## WEST SUSSEX COUNTY COUNCIL CONSULTATION

| <b>LOCATION:</b>                | 55, Sea Lane Gardens, Ferring, BN12 5EG                                                                                                                                                                                                    |
| <b>SUBJECT:</b>                 | FG/94/18/PL<br>Erection of 1 No. bungalow.                                                                                                                                                                                                 |

Drawing
Site Plan

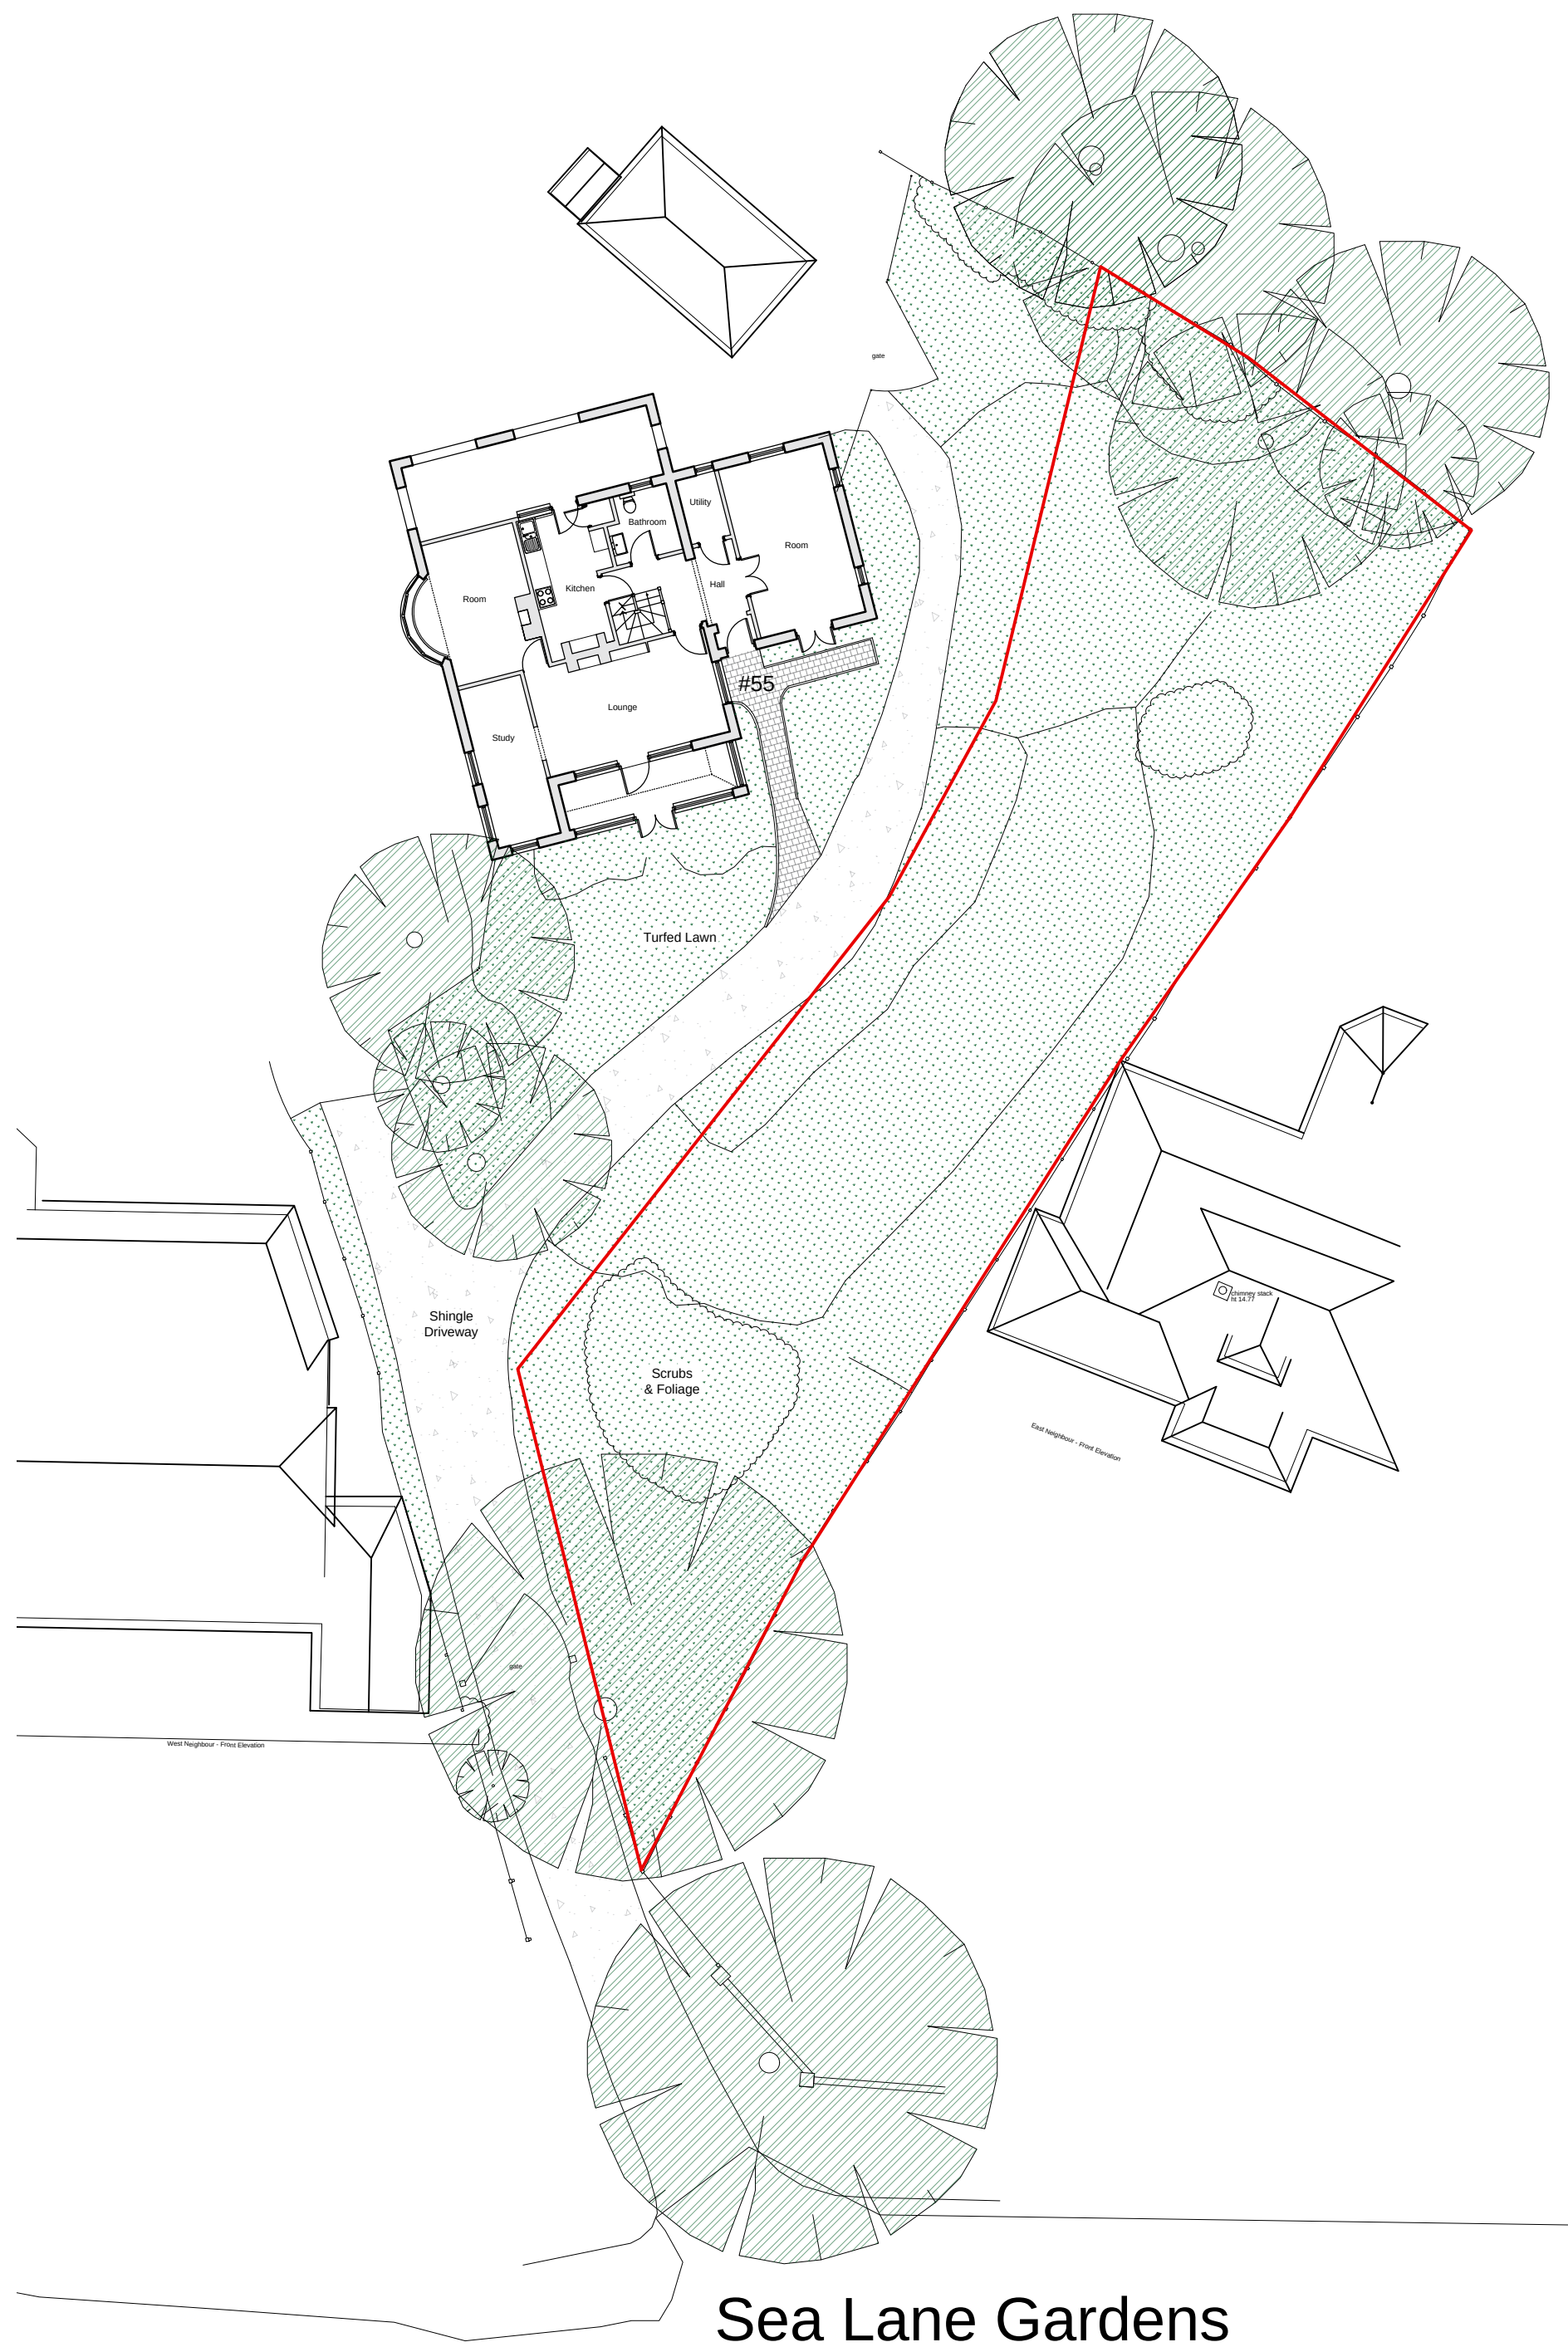
The plans detail a new access via the existing private access road off of Sea Lane Gardens. The applicant must secure the necessary permissions from the proprietor of the private access road before any works to create the new access commences.

Given the narrow access to the site with limited space for large delivery and construction vehicles to turn either within the site or along Sea Lane Gardens, the LHA would suggest that the applicant provide a construction management plan to detail how they plan to manage deliveries to and from the site during construction.

The WSCC car parking calculator would envision 2 parking spaces for a dwelling of this size in this location which has been met by the plans. The LHA would prefer a turn on site, however there is not sufficient space on site for this. Given the low traffic along the private access road and similar existing neighbouring situations, the LHA would not anticipate that vehicles reversing from the site onto the private access road would cause a 'severe' highway safety concern.
